## OFFICER'S REPORT

APPLICATION NUMBER: S6/2003/1311/FP

LOCATION: Wyndham Cottage, Camfield Place, Essendon

PROPOSAL: Erection of two storey side extension and rear conservatory

FOR FRESHOLDERS: MRAUS ADKIN  
 MR & MRS J AND M ADKIN, WYNDHAM COTTAGE, CAMFIELD PLACE, ESSENDON HEATHS AL9 6SE  
 PROPOSED GABLED GROUND FLOOR EXTENSION + GROUND FLOOR CONSERVATORY  
 DRAWING NO. 1 PLAN ELEVATIONS. RED MARKS PROPOSE AREA. AUGUST 03  
 SCALE APP 2cm to 1 metre 1:50

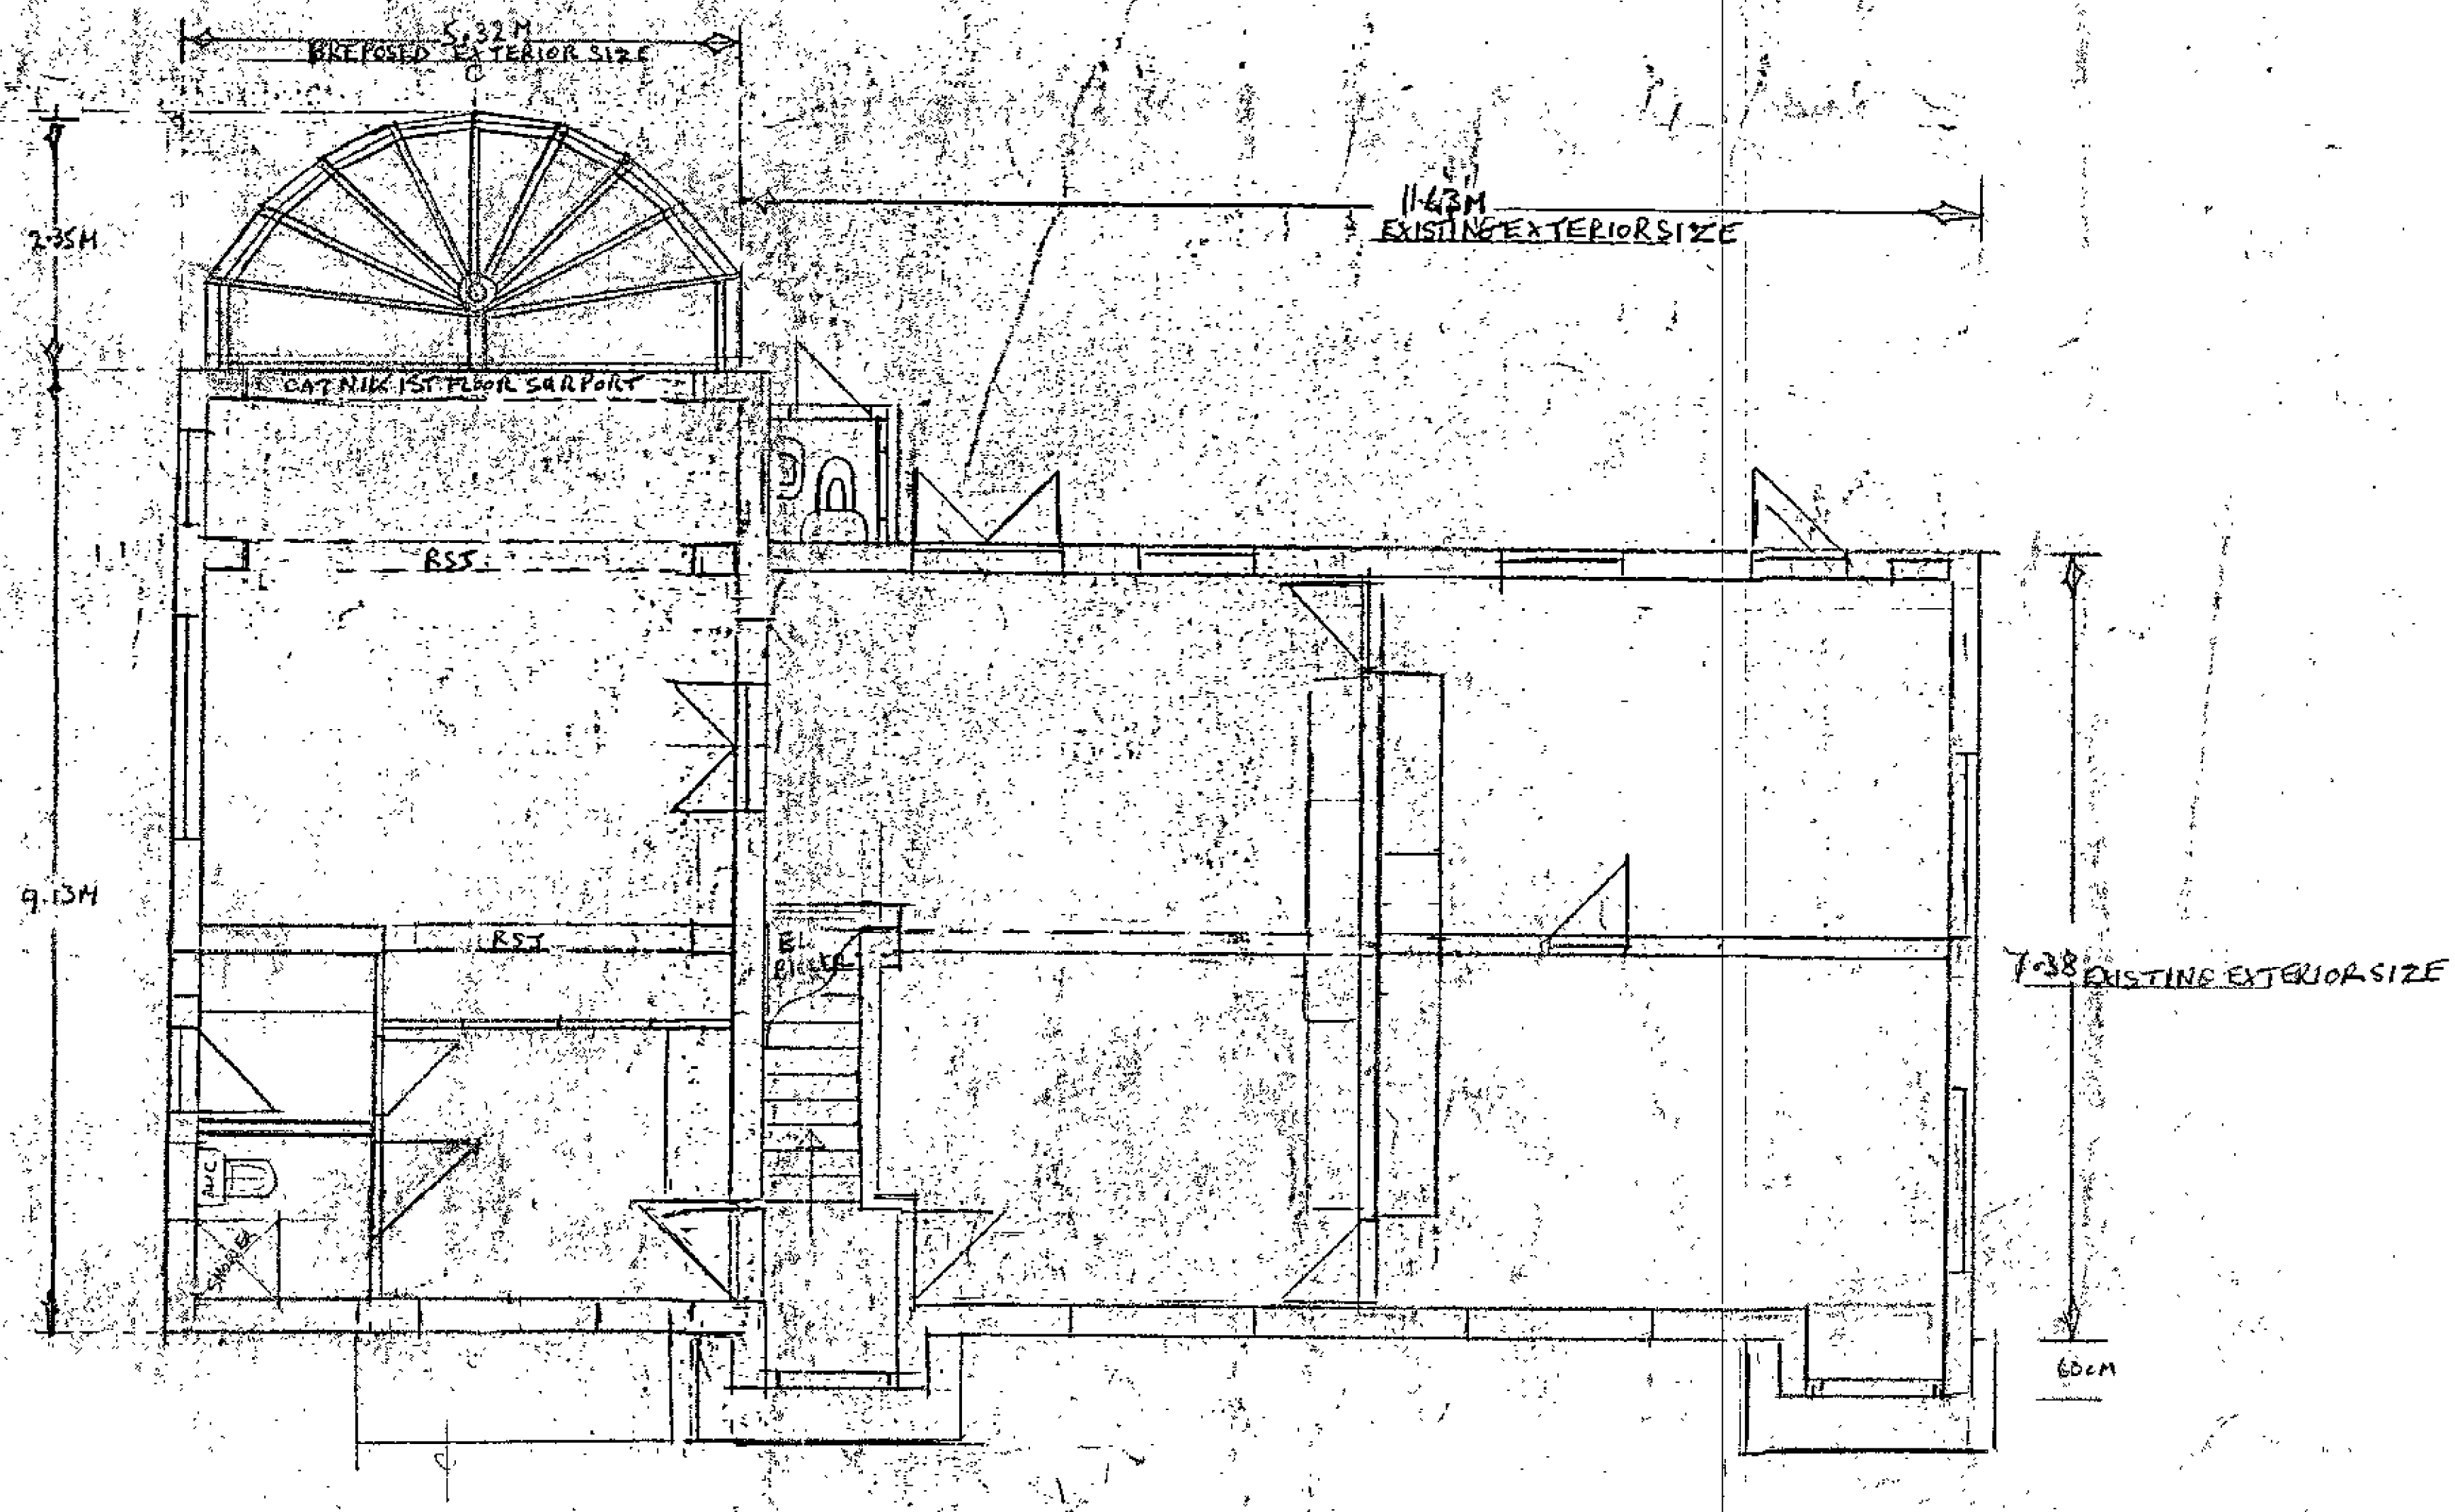
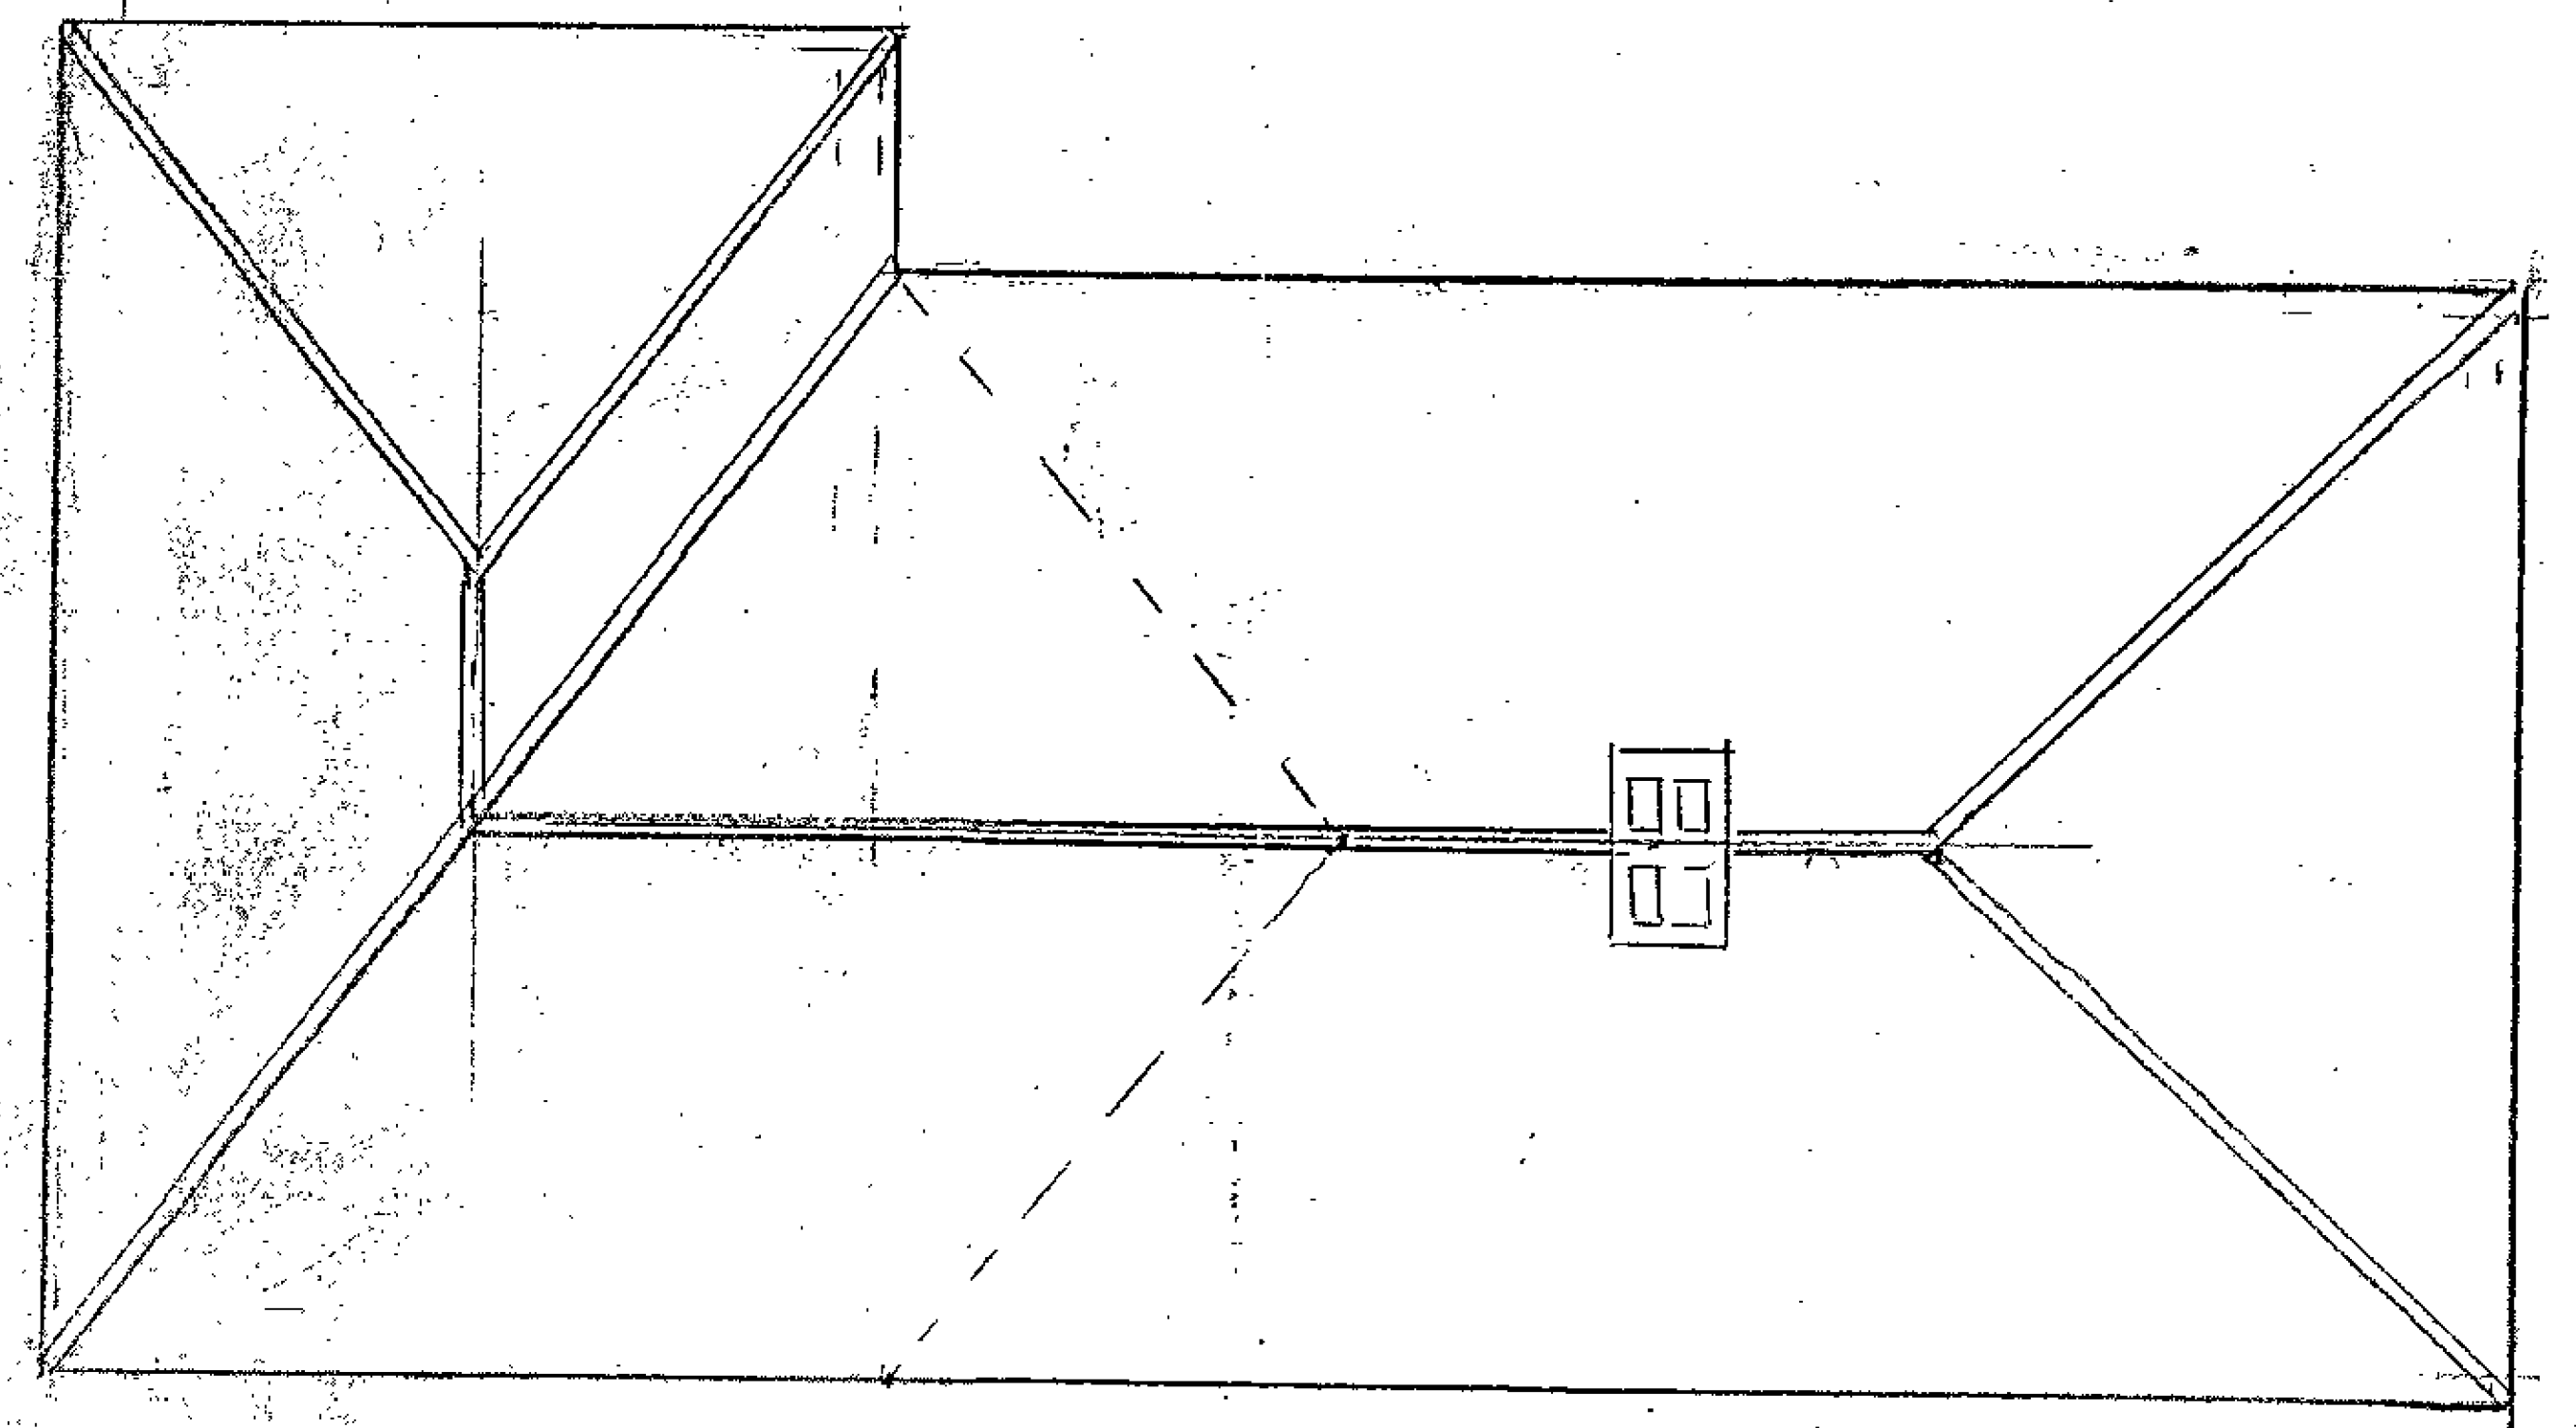
In terms of the Council's Residential Criteria, the application is also not acceptable. The extension would not be subordinate to the original dwelling and does not reflect the design or character of the house through the introduction of a gabled roof. The extension would also visually unbalance the appearance of the dwelling. Due to its isolated location and position away from the road the extension will accord with all other aspects of this policy.
